2024/0813

██████████
28 Royd Lane, Higham, Barnsley, S75 1PH

Two storey side extension and front porch.

Drawing Title **PROPOSED PLANS**

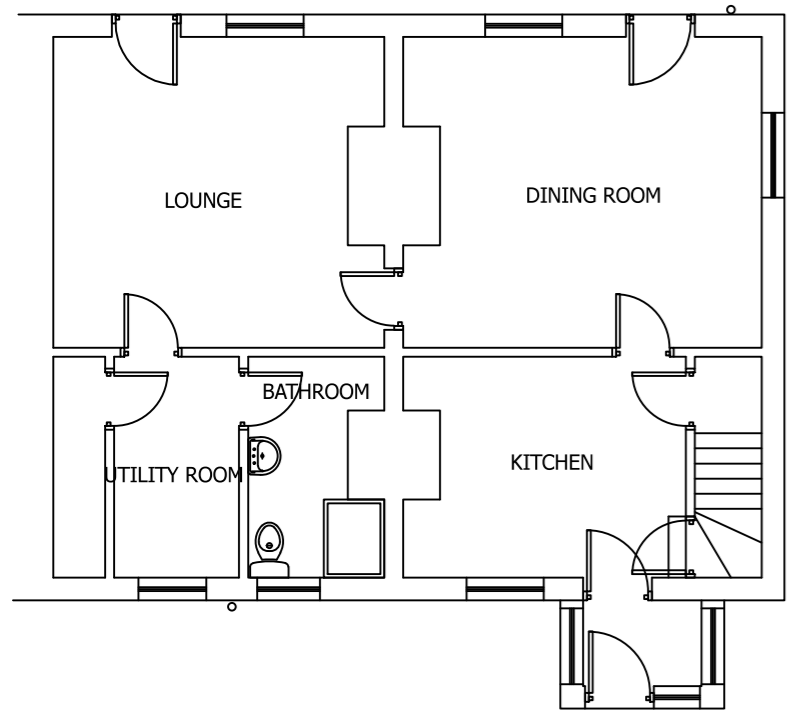
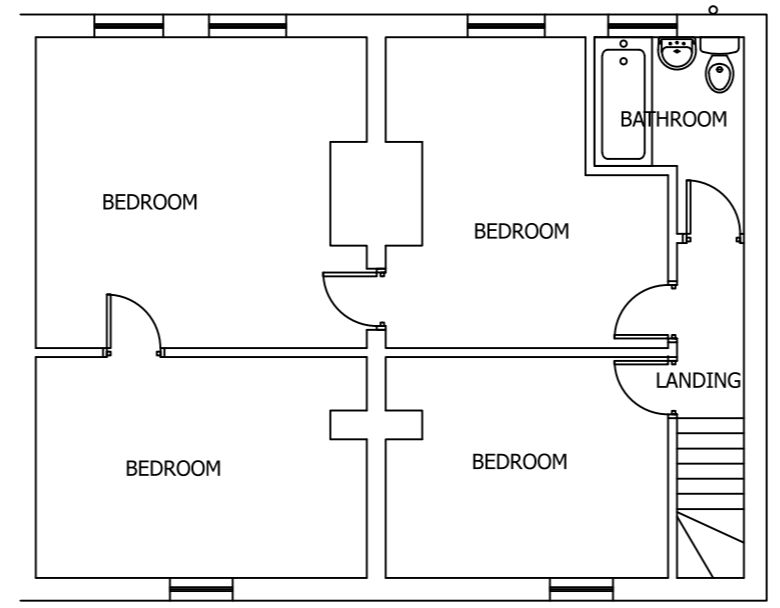
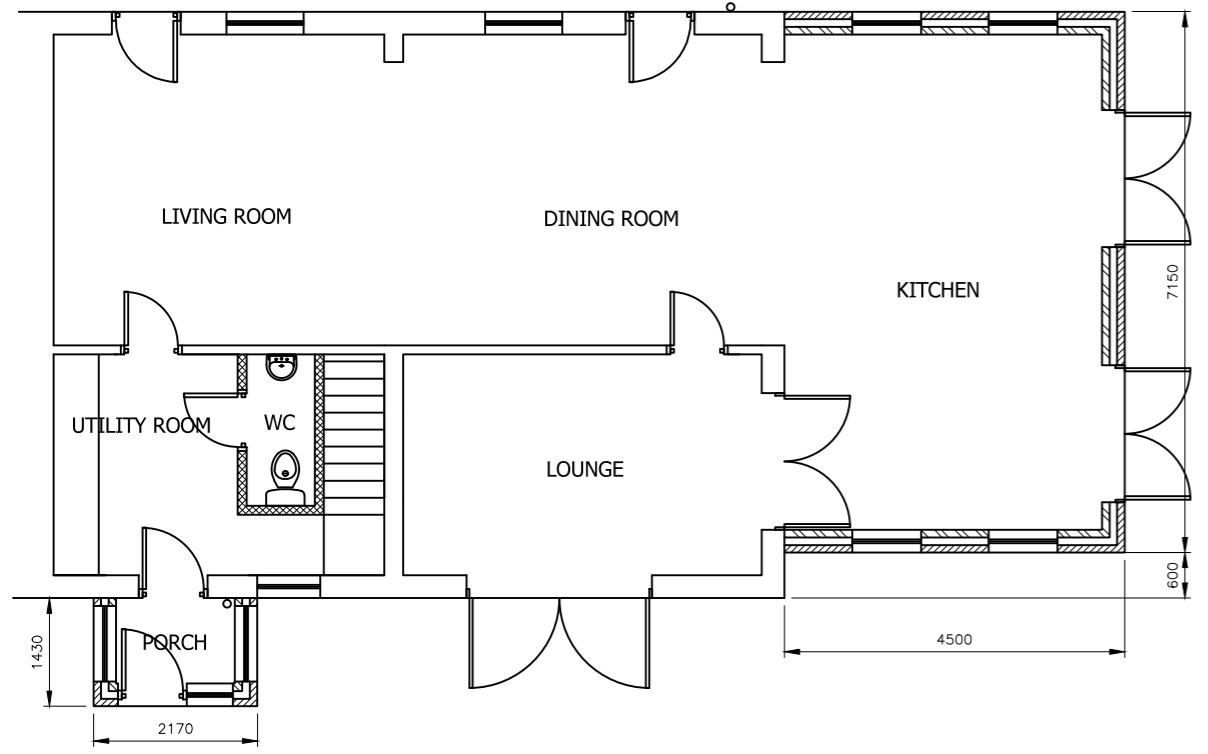
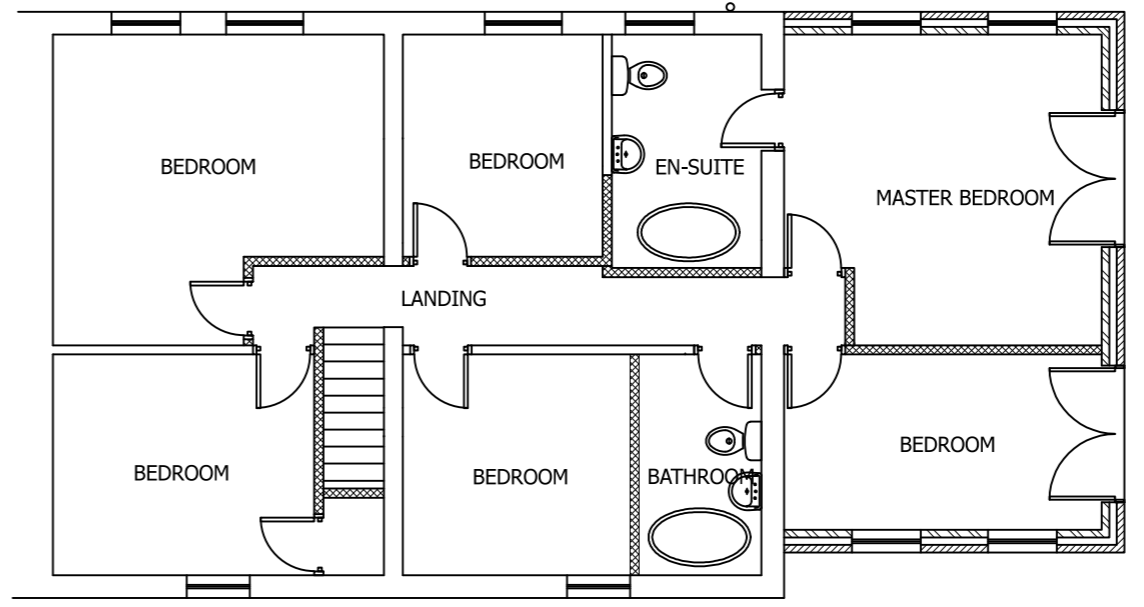
The two properties prior to conversion are therefore considered the original buildings. The original buildings have a total original floorspace of approximately 165.2m² measured externally over two storeys, while the proposals, including existing outbuildings, would result in approximately 119.31m² of cumulative floorspace. The proposals are therefore not considered to amount to more than a doubling of the original buildings, in accordance with Local Plan Policy GB2. Nevertheless, to avoid any further potential harm to the Green Belt, some permitted development rights will be removed.

The proposed side extension would be erected on the north-west facing side elevation of the dwelling and away from surrounding neighbouring properties. Any potential overshadowing would therefore likely be limited to the application curtilage. The proposed porch would be erected to the north of and adjacent to a neighbouring porch of a similar scale. The proposed porch is therefore unlikely to result in significantly increased overshadowing.

Drawing Title **PROPOSED ELEVATIONS**

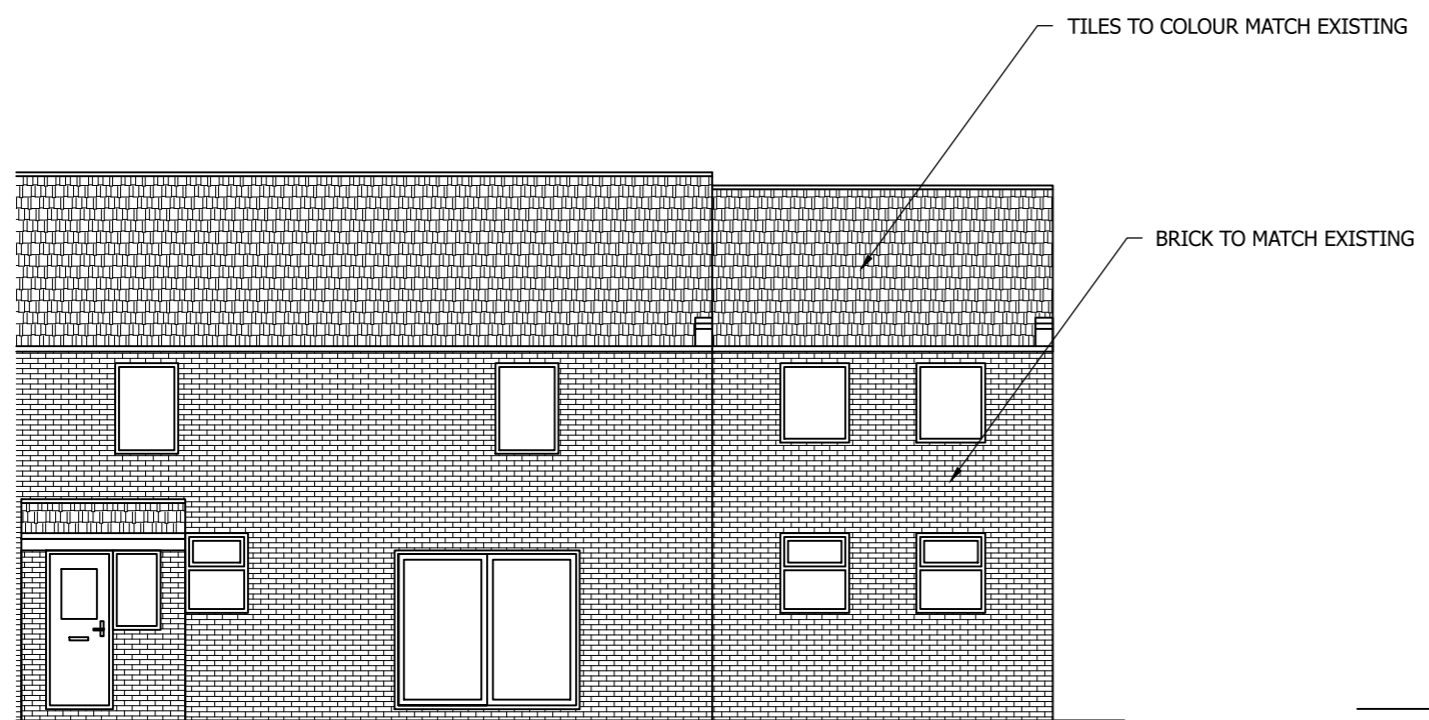
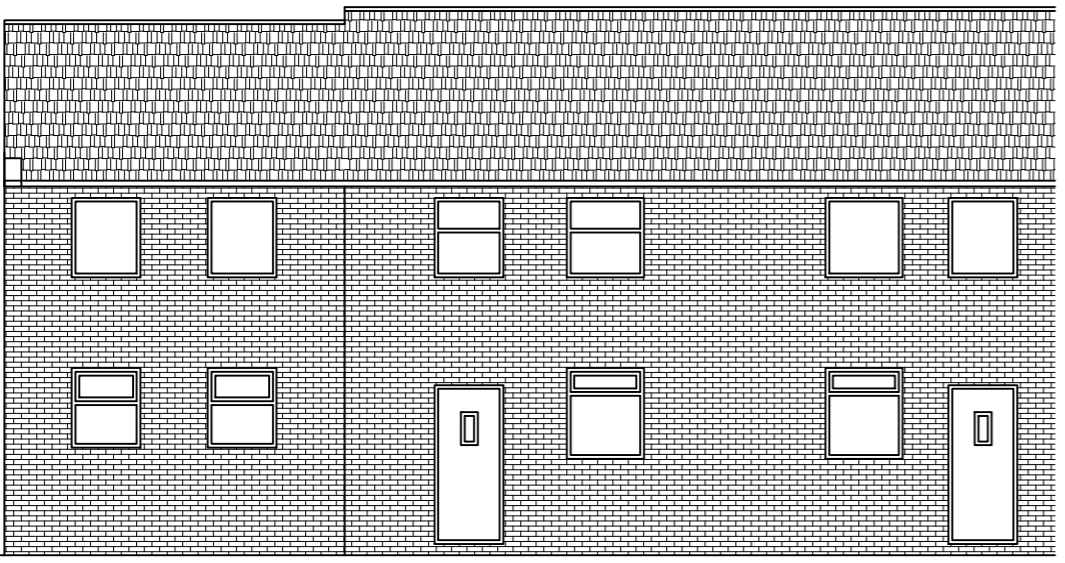
The proposed side extension would adopt a sympathetic form and features, including a pitched roof, closely matching external materials and a modest scale. The extension would be set back from the north-east facing elevation of the dwelling and would be set below the ridge of the existing roof. The extension would adopt a sideways projection of more than two-thirds the width of the original dwelling (28 Royd Lane), contrary to the House Extensions and Other Domestic Alterations SPD. However, at some point, 26 Royd Lane and 28 Royd Lane were converted into a single larger dwelling which now forms the current application property and curtilage. The proposed extension would not appear excessive in relation to the combined width of the converted properties. Moreover, as the application site is set away from the principal highway, the extension would not be prominently visible and would therefore not significantly alter nor detract from the character of the street scene. Likewise, the provision of patio doors on the north-east facing elevation would be acceptable in this instance, given the backland location of the application property.

The proposal includes first-floor windows located on all elevations of the side extension. The north-east facing windows would face towards the residential curtilage of The Cowshed. However, while these windows could contribute to increased overlooking, any potential impact would likely be similar to that which exists because of existing first-floor windows facing the same direction. Moreover, the occupant(s) of The Cowshed were notified of the application and no objections were received. The north-west facing windows are larger with Juliet balconies but would face into the application site. The south-west facing windows would face towards an area of private land with the M1 motorway beyond. However, the land is comprised of vegetation overgrowth and detached outbuildings with the gradient falling to the south-west therefore reducing any potential overlooking and loss of privacy. Moreover, any potential impact would likely be similar to that which exists because of existing first-floor windows facing the same direction.
